CITY OF ALBUQUERQUE
PUBLIC WORKS DEPARTMENT

SUBJECT: PRIVATE DRAINAGE FACILITIES WITHIN PUBLIC RIGHTS-OF-WAY/EASEMENT
PENTECOSTAL HOLINESS CHURCH OF DELIVERANCE - (L-21/D34)

RE: REVISED DRAINAGE PLAN FOR PENTECOSTAL HOLINESS CHURCH
OF DELIVERANCE (L-21/D34) REVISION DATED OCTOBER 15, 1990

RE: DRAINAGE PLAN FOR PENTECOSTAL HOLINESS CHURCH
OF DELIVERANCE (L-21/D34) RECEIVED SEPTEMBER 18, 1990
ENGINEER'S STAMP DATED SEPTEMBER 17, 1990

SITE, LANDSCAPING AND DRAINAGE PLAN 1/8" = 1' - 0"

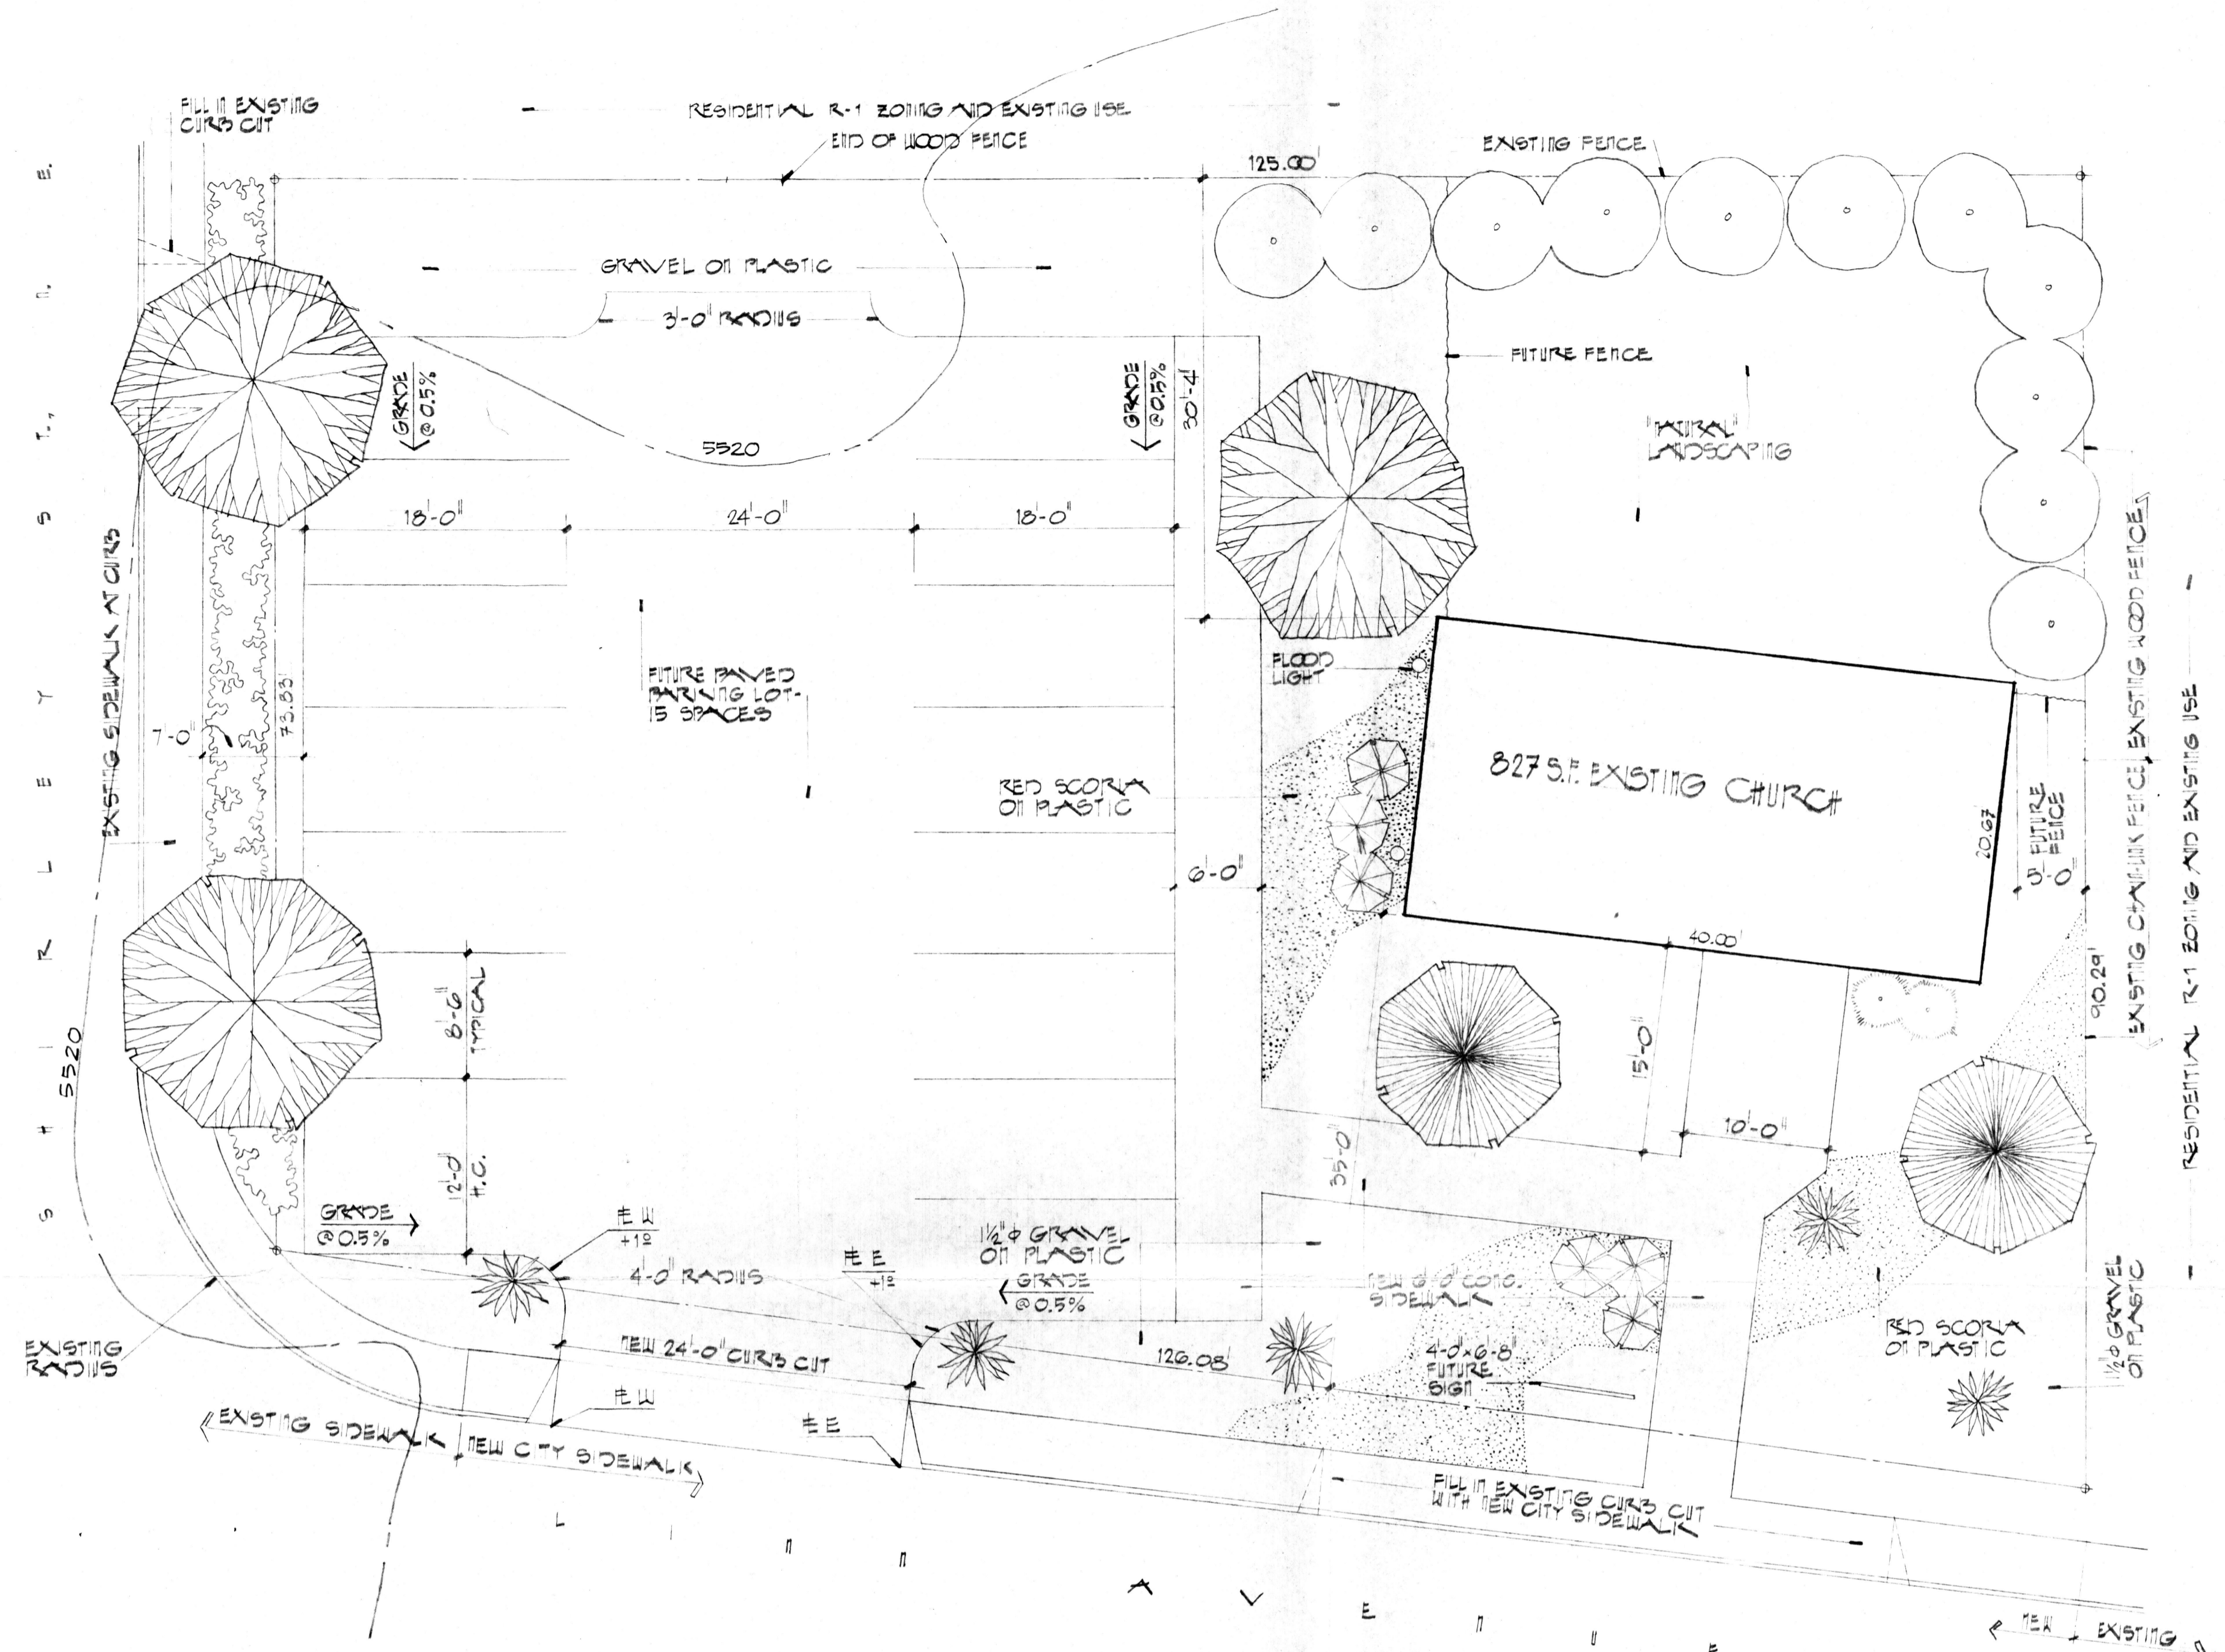
1. Scales - recommended engineer scale
 - a. 1" = 20' for site less than five acres.
2. Legend - for drainage purposes, see D.P.M. Volume 2 Tables 27.3a - 27.33d for recommended standard symbols.
3. Existing contours shown on plan drawing.
4. Contours must extend a minimum of 25' beyond property lines.
5. Conceptual erosion control plan - a written or graphic description of the sites erosion control needs.
6. Existing top of curb and flow line elevations on both streets.

GRADING PLAN 1" = 10'

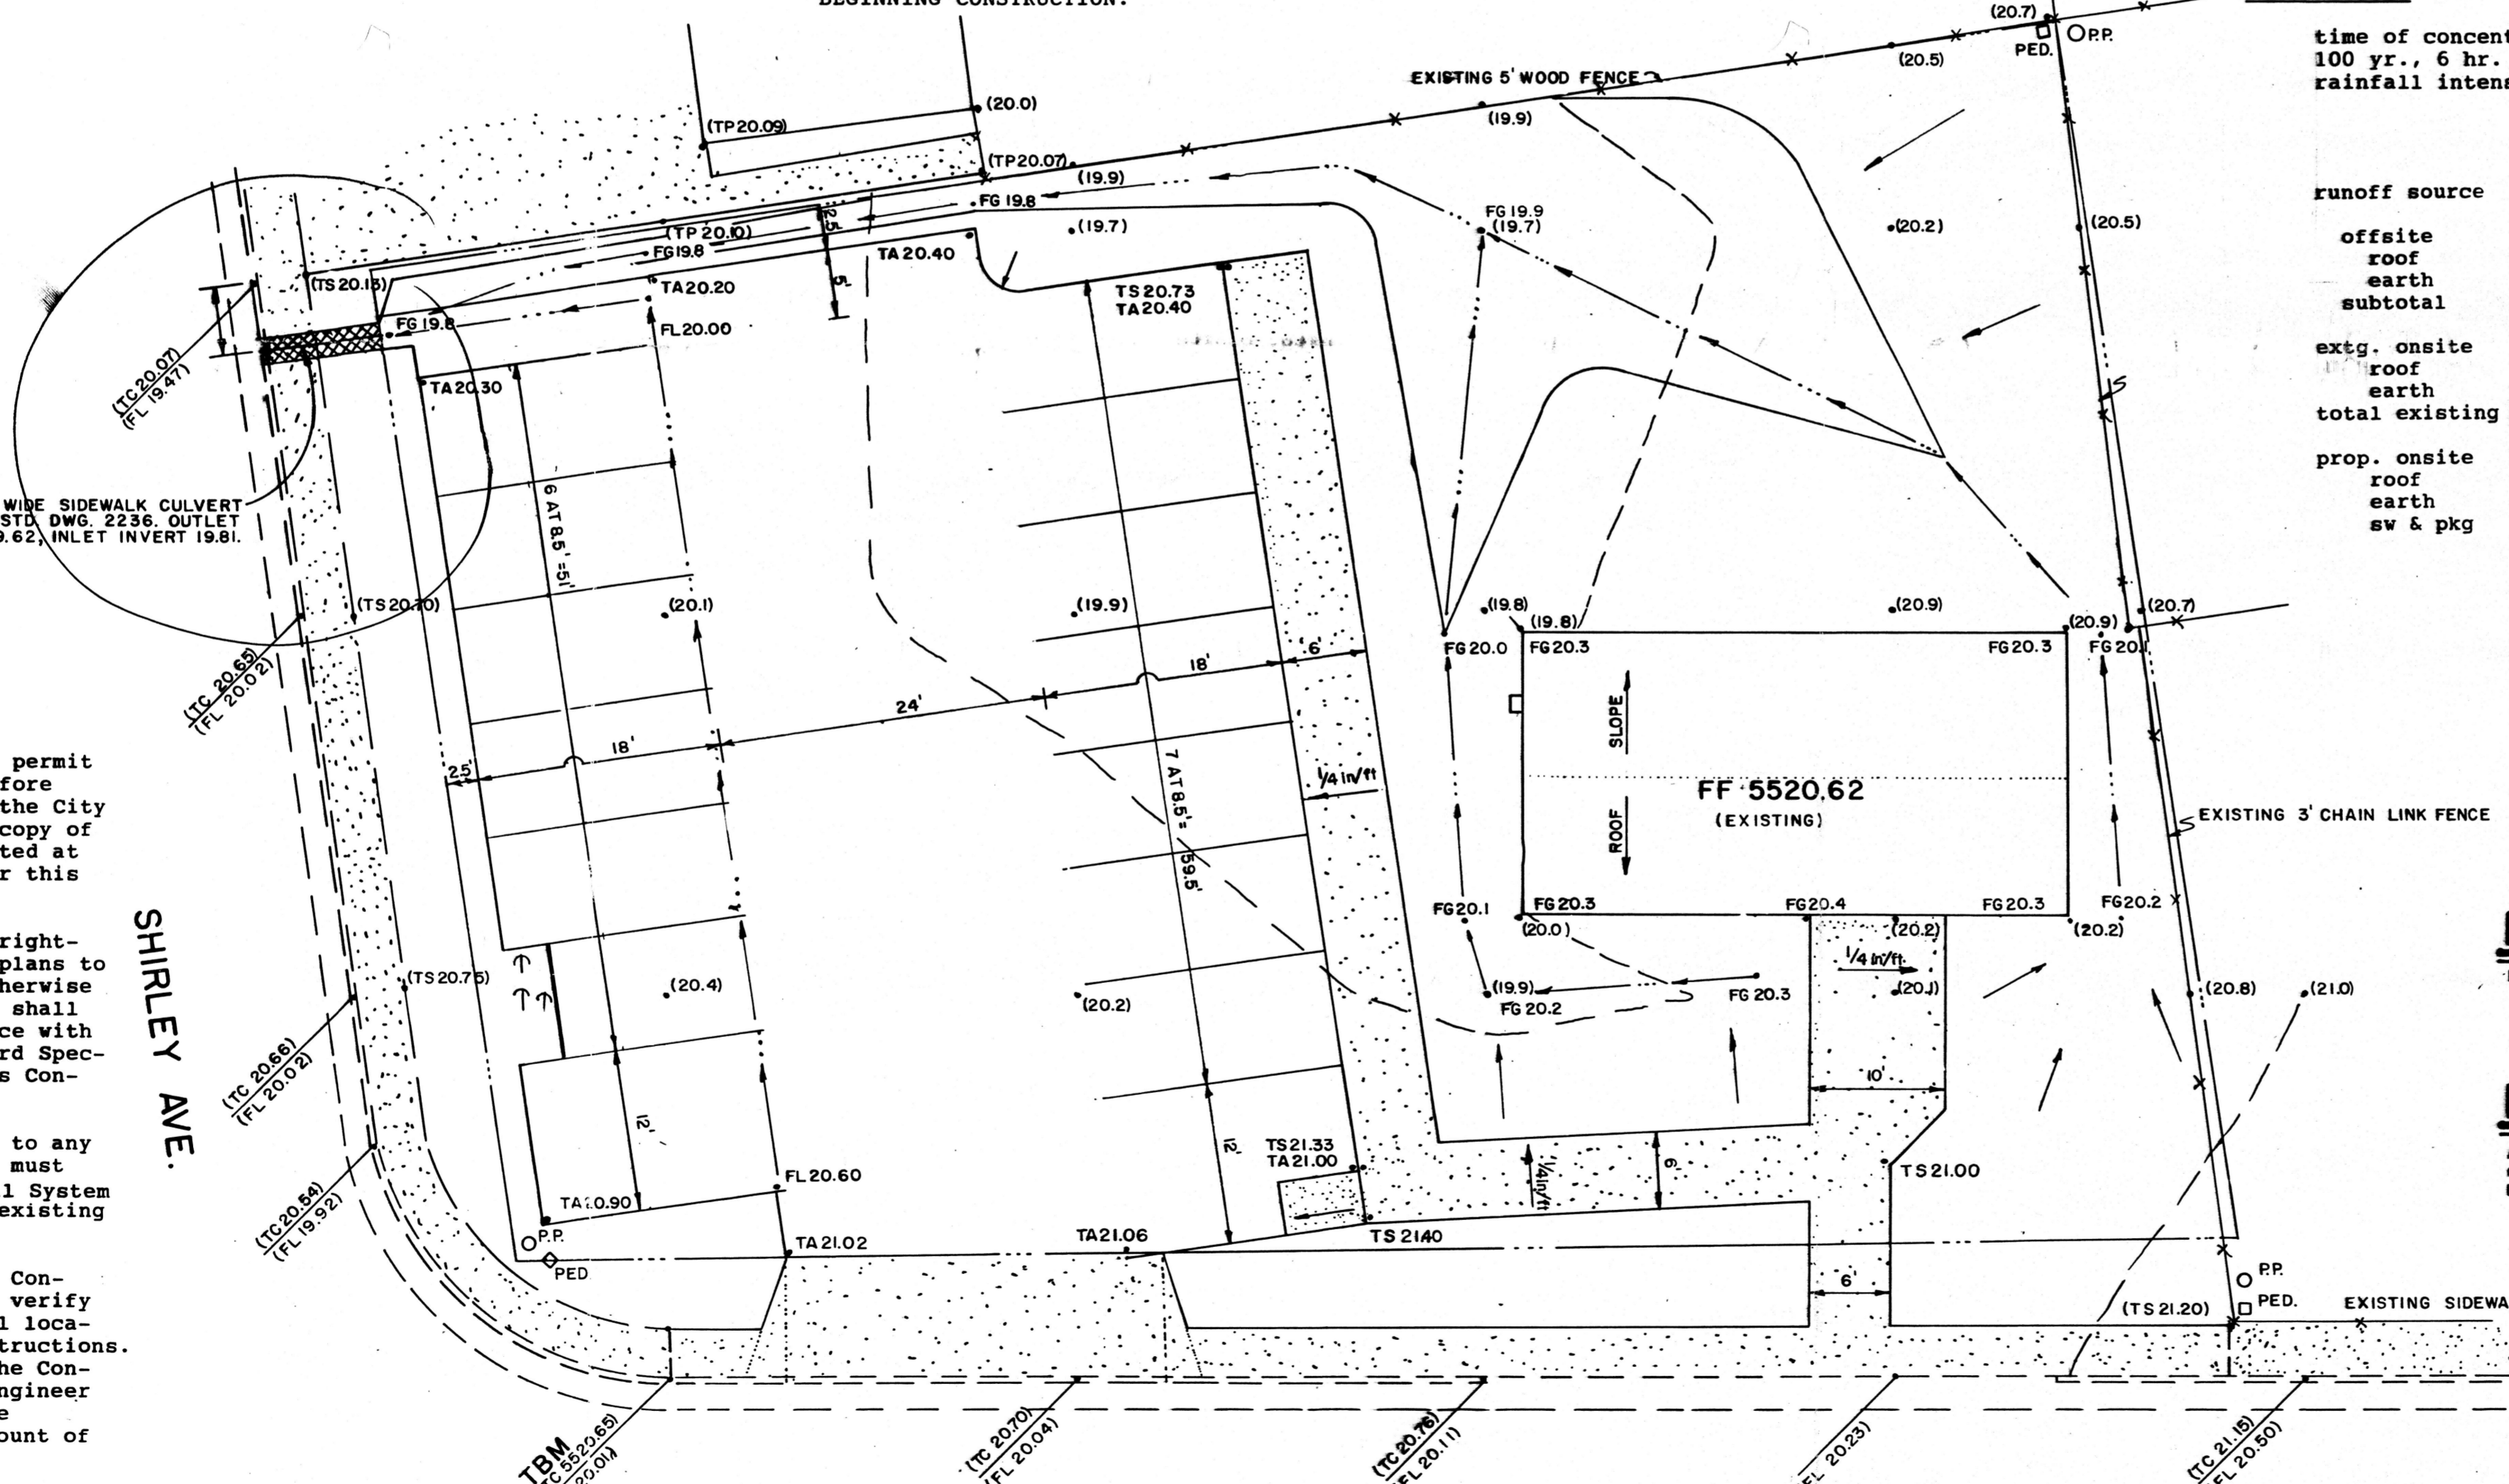
1. Please identify within the plan drawing your basin lines. I am unable to determine which is which. **PONDS & BASINS DELETED**
2. Ordinance specifies that all ponds must be drained within 24 hours or less. No retention ponds are allowed. **PONDS DELETED**
3. Also, no ponds are allowed within 15' of a structure without a soils report. **PONDS DELETED**
4. Please identify where the offsite flows enter and also quantity. **SHEET FLOWS QUANTIFIED IN NEW CALC.**
5. North arrow is missing. **ADDED**
6. You will need to include the six notes to contractor and sign-off blocks from the S.O. #19 format within the plan drawing. **ADDED**
7. Please include the adjacent street names. **ADDED**
